Observations By:	KC, Highways Development Management
Application No.	2020/90805
Proposed Development:	Reserved matters application pursuant to outline permission 2015/90430 for erection of residential development comprising (Use Class C3) and incorporating associated new access (to Crossley Lane and Cold Royd Lane), and associated works (126 dwellings)
Location:	Land to North and South of, Crossley Lane, Dalton, Huddersfield, HD5 0QP
OS Map Reference	SE 417425.5056417339.3308
Applicant/Agent:	JRP
Class:	Small Major Developments

Consultation Response from KC, Highways Development Management		
2020/90805 Land to North and South of, Crossley Lane, Dalton, Huddersfield, HD5 0QP		
Reserved matters application pursuant to outline permission 2015/90430 for erection of residential development comprising (Use Class C3) and incorporating associated new access (to Crossley Lane and Cold Royd Lane), and associated works (126 dwellings)		
Date Responded:01/07/2020	Responding Officer: Mark Berry	Responding Ref: 11-8SW-1

Scale	Date	Drawn
1:500 @ A1	MAR 16	MI
Drg. No.	906/03/SK4	Rev D

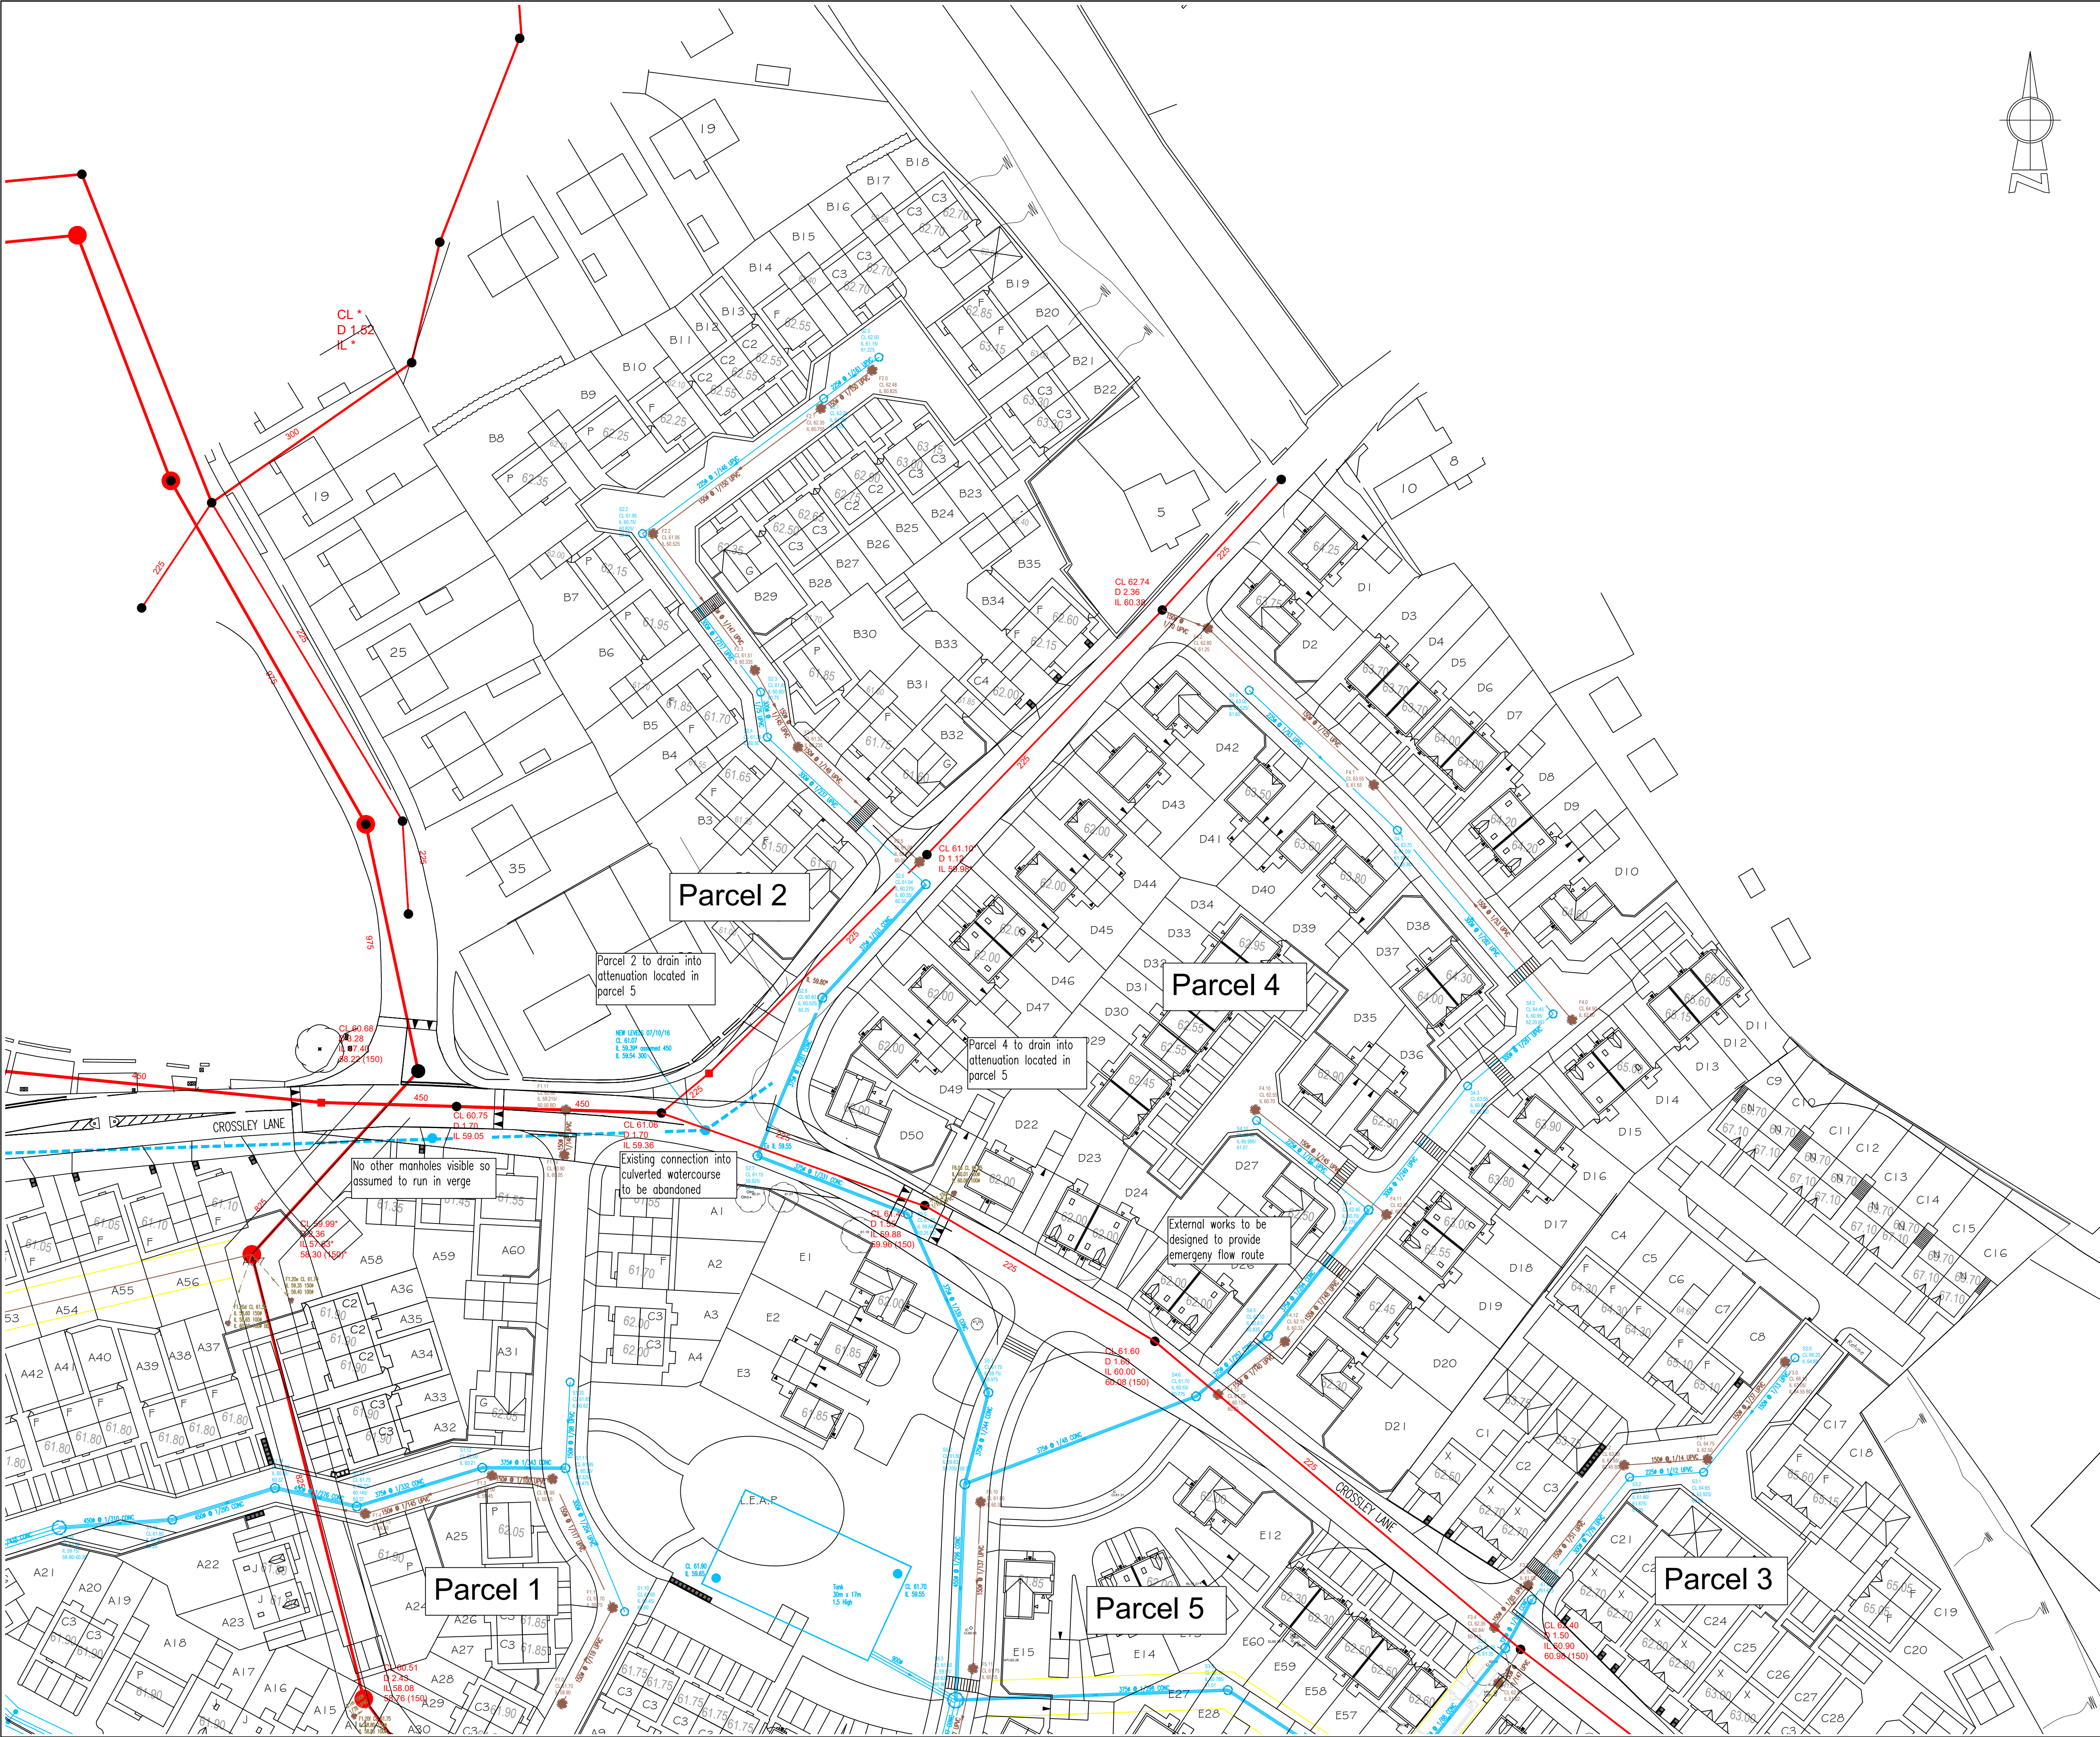
The plans should be dimensions.

Swept paths should be provided through the site from Crossley Lane and Cold Hill Lane to demonstrate that an 11.85m refuse vehicle can enter, exit and turn within the site.

Details of forward visibility should be provided across the changes in direction through the site.

Bin collection points should be shown to be provided to all plots

Shared private driveways should have turning facilities sufficient in size to accommodate a 7.0m long delivery van.
